CITY OF ALBUQUERQUE

December 2, 2014

**Re: Abundant Life Gymnasium
Grading and Drainage Plan
Engineer's Stamp Date 11-24-14 (M10D006)**

H  
C-2.0

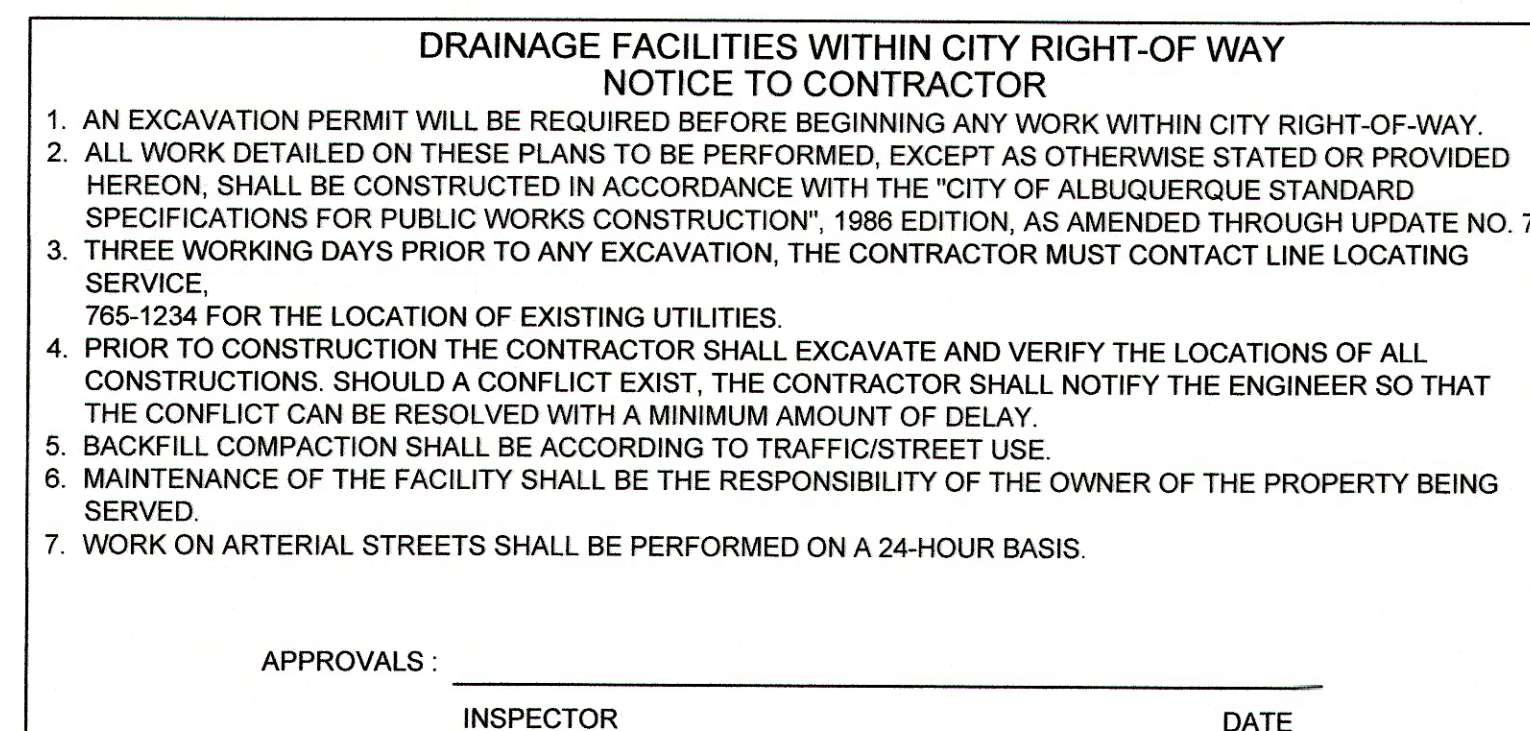
6. The overflow spillway at the beginning of the channel is 88.0, but the end of the channel is 88.40 which is higher. Revise the spot elevations.
7. Provide more spot elevations for the swale on the east in the existing parking. Will storm water be able to drain out of that area?

J  
C-2.0

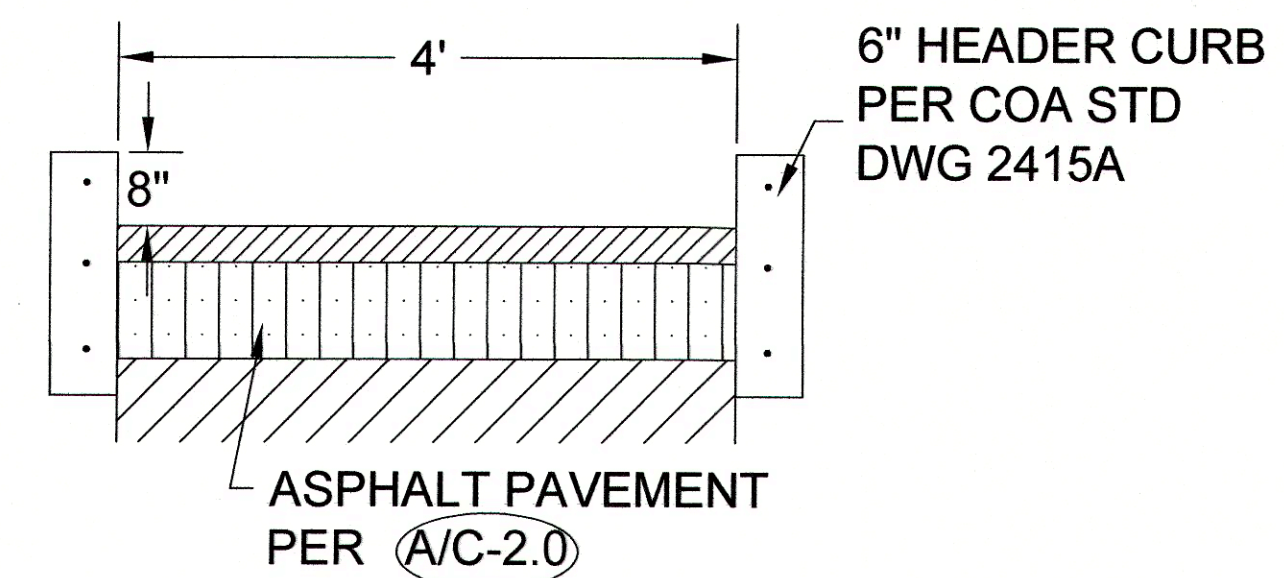
2. When requesting SO-19 approval, provide two sets of paper copies of the plans.
3. For Detail J/C2.0, what are the various width and length dimensions of the channel?
